24 September 2018

File No: 2018/487955  
Our Ref: R/2018/12/A  
Your Ref: SSD 9347

**RE: Amending Stage 1 Concept Proposal (south site building envelope)  
Sydney Metro Martin Place (SSD 9347)**

Stage 1 amending DA envelope with City
of Sydney suggested 8x8m notches

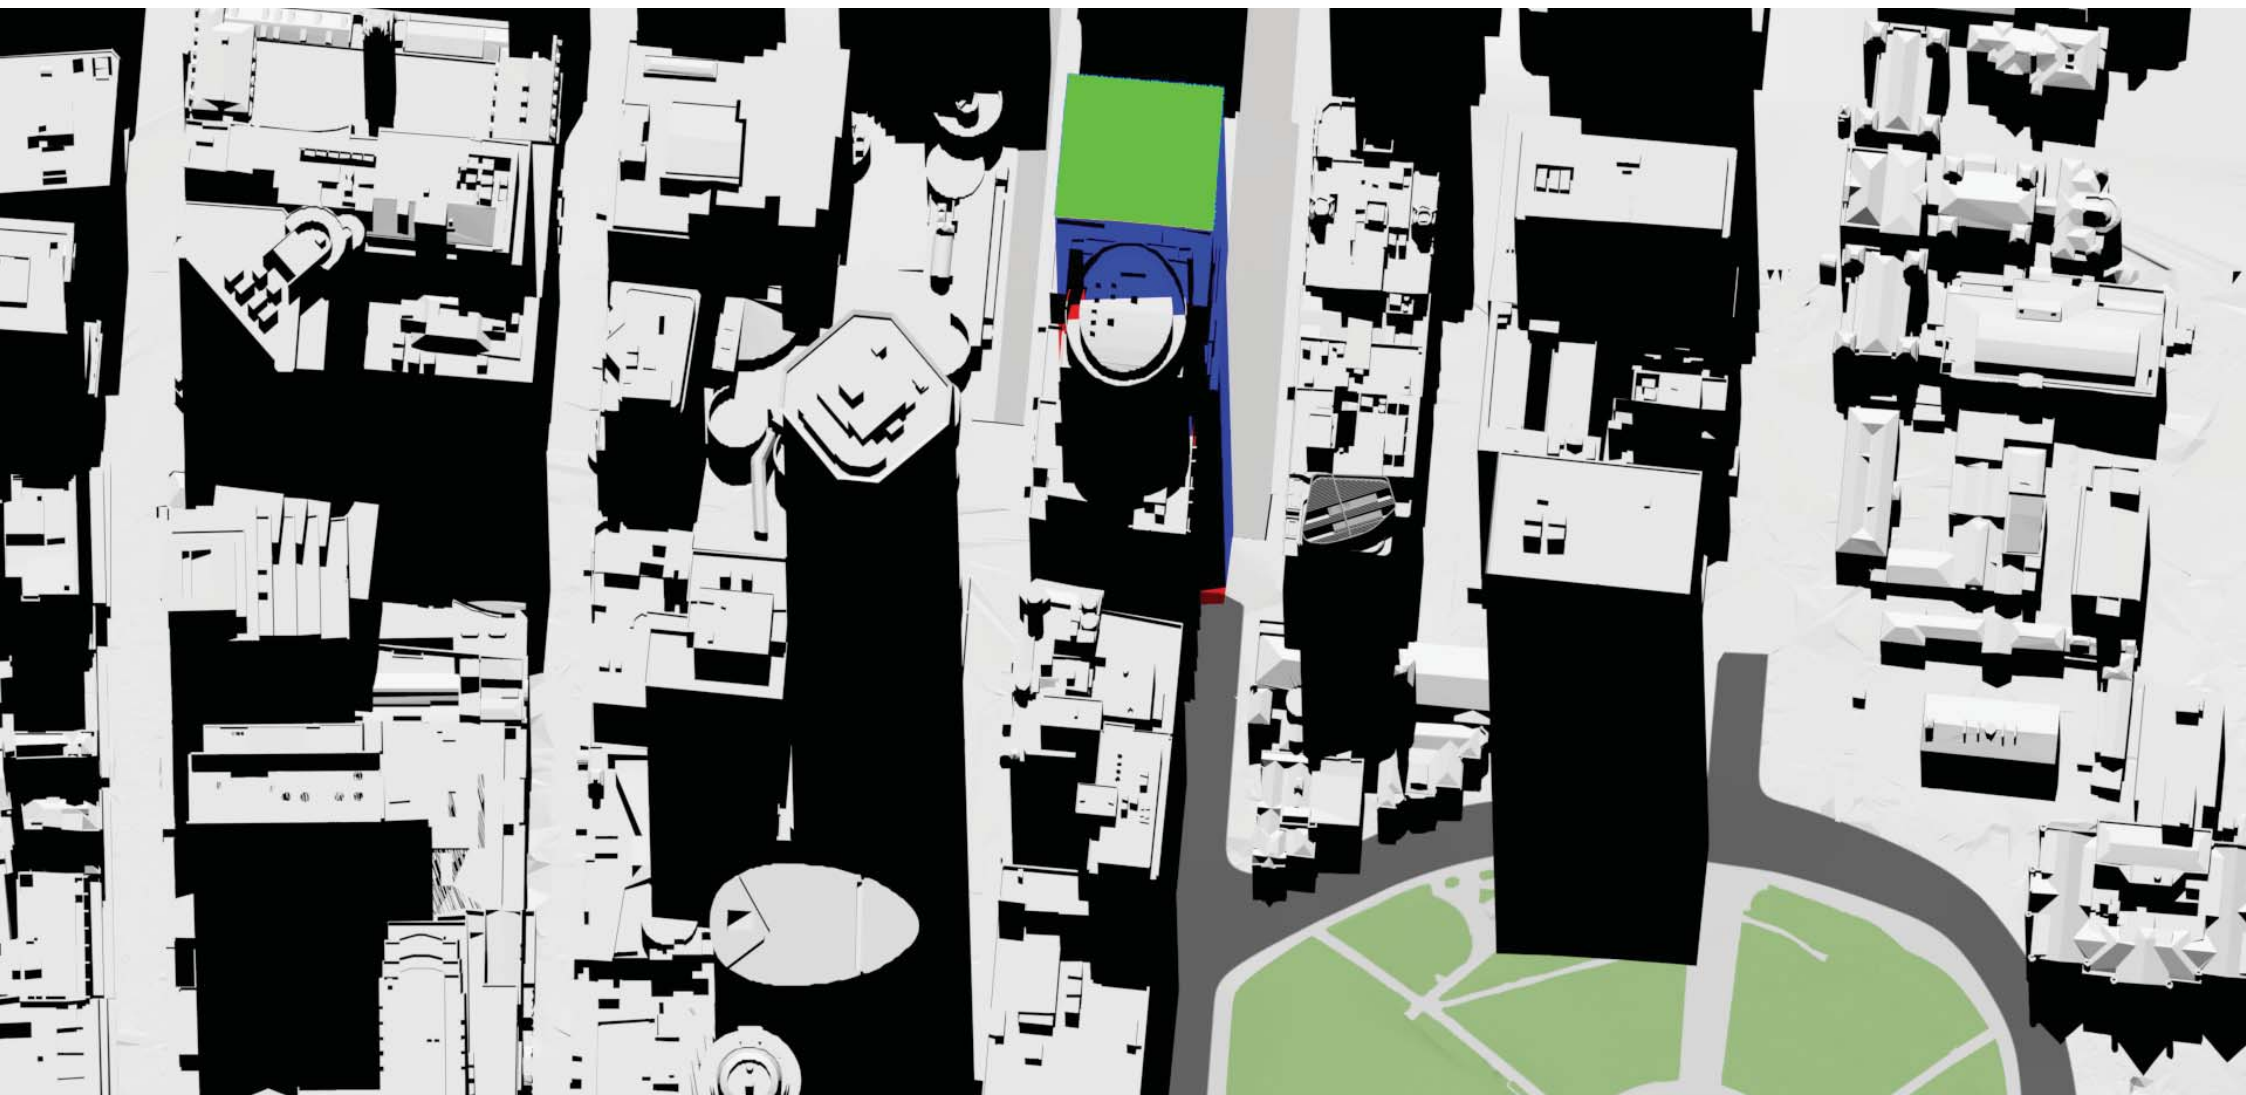
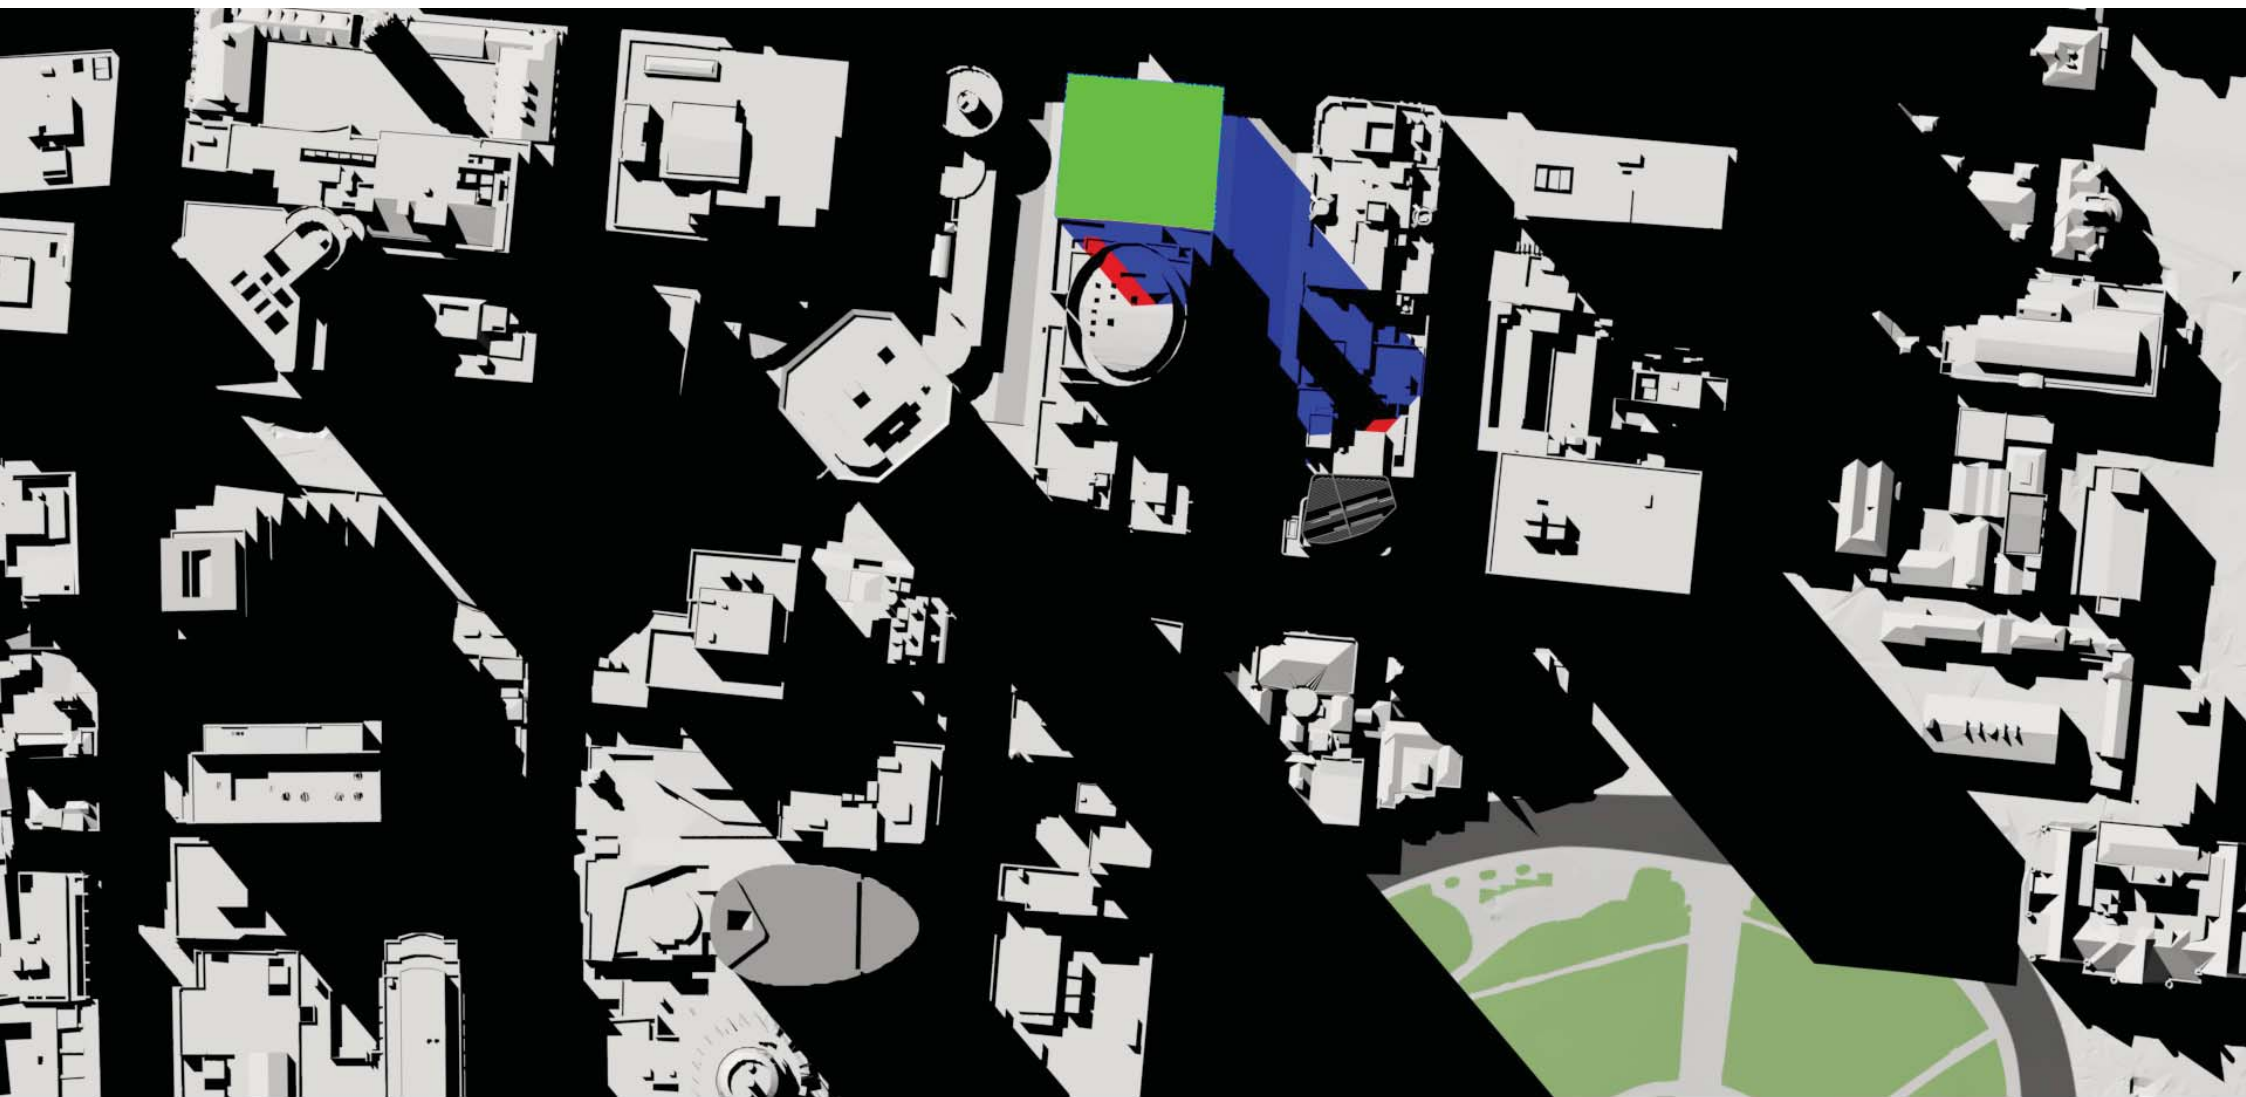
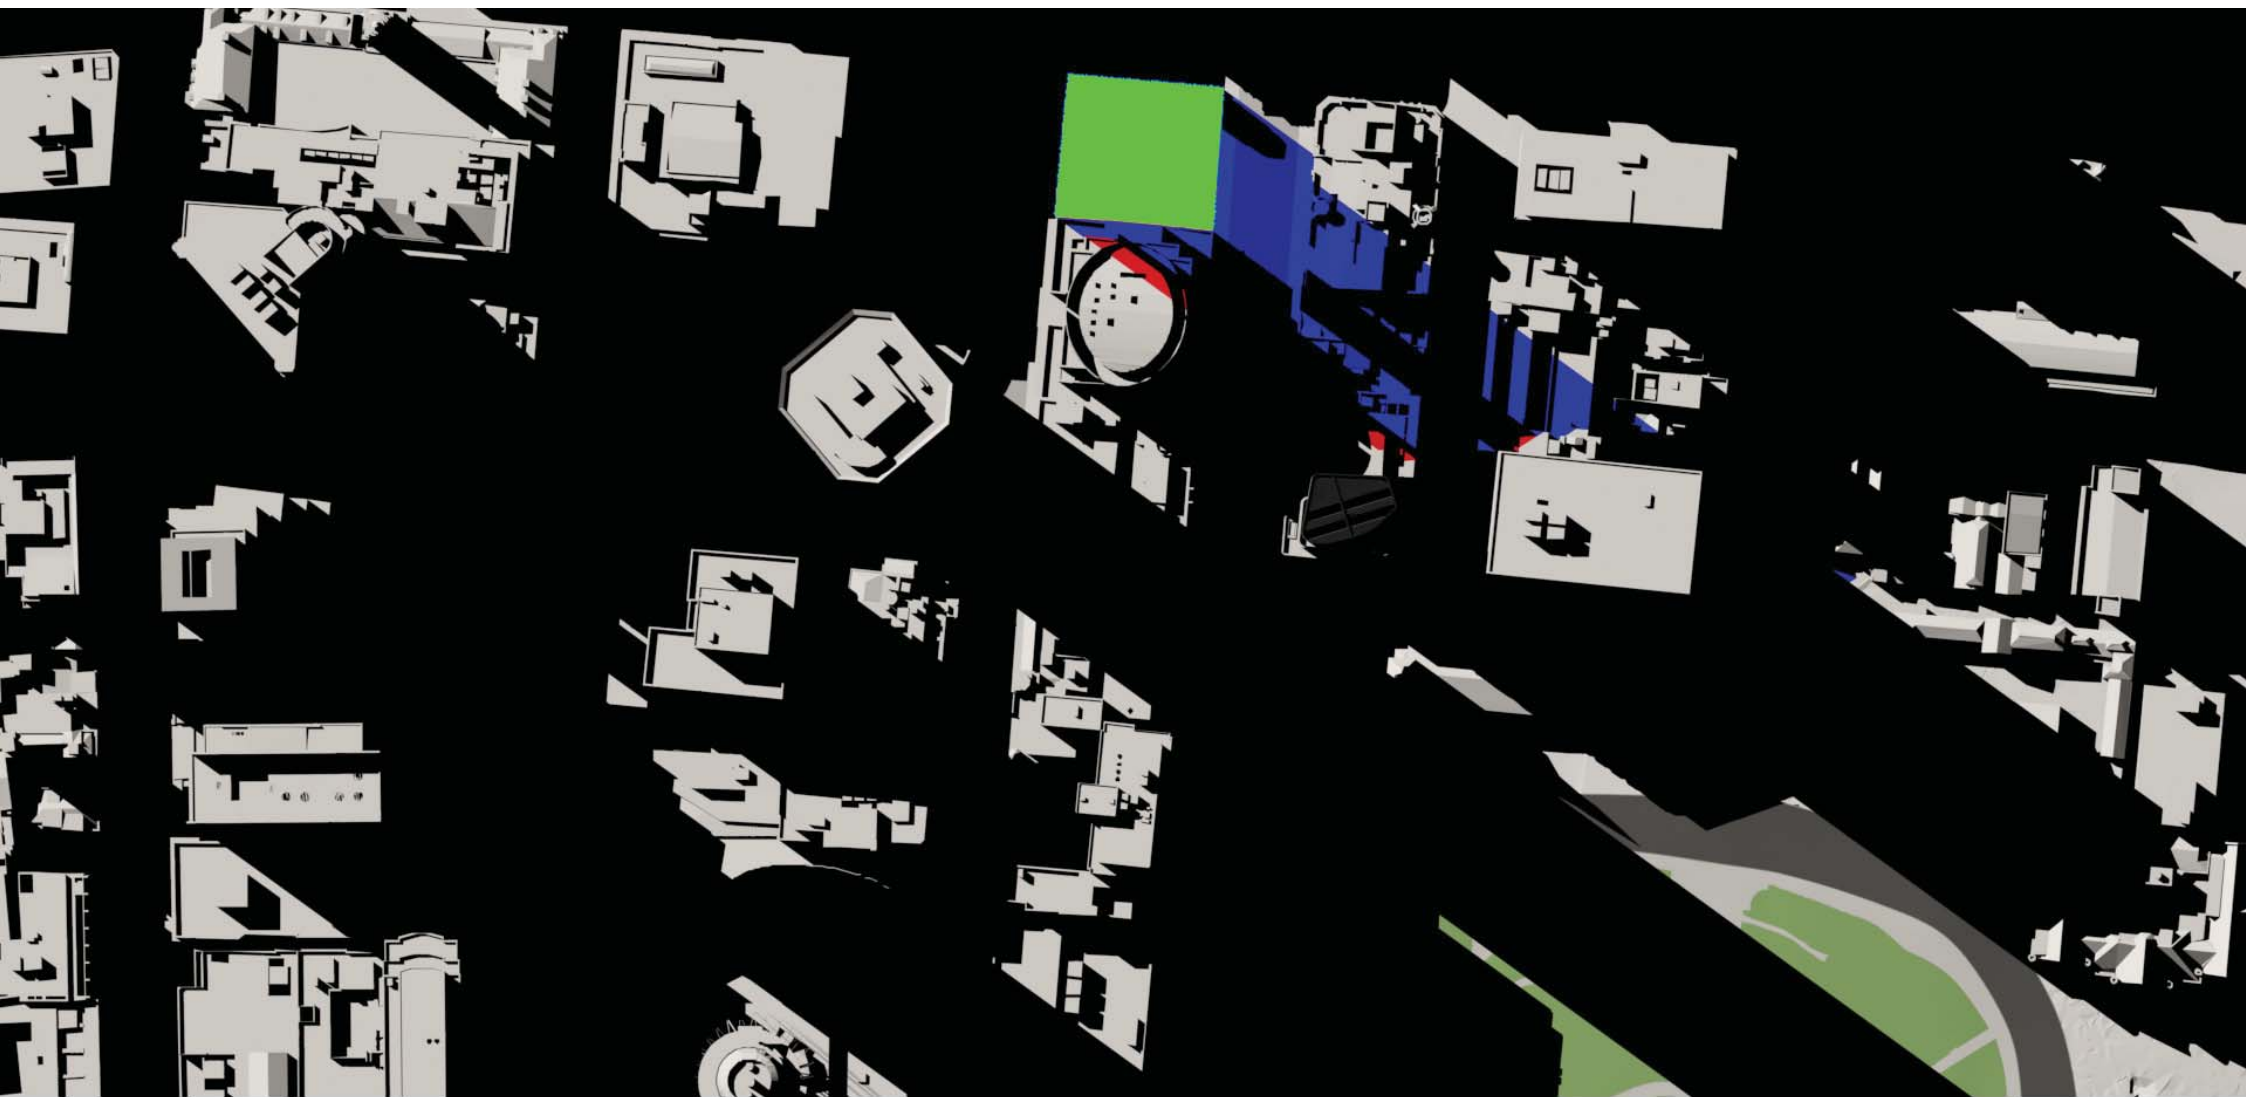
In lieu of incorporating the Planning Assessment Commission's (PACs) recommendations regarding street frontage conditions along Elizabeth and Castlereagh Streets as part of the existing concept approval (SSD 8351), it is recommended that in amending the concept envelope and increasing the building mass of the south tower, building returns be incorporated in the southern corners of the envelope as a transition to the adjoining development to the south above the podium height. This would in part assist in achieving the outcome of the PACs' advice of reinforcing the importance of the urban character and integrity of Martin Place and the associated city blocks. A return of 8m x 8m is recommended for each corner for the tower above a nominal 45m podium height.

An attached diagram from the proposed concept envelope illustrates this recommendation.
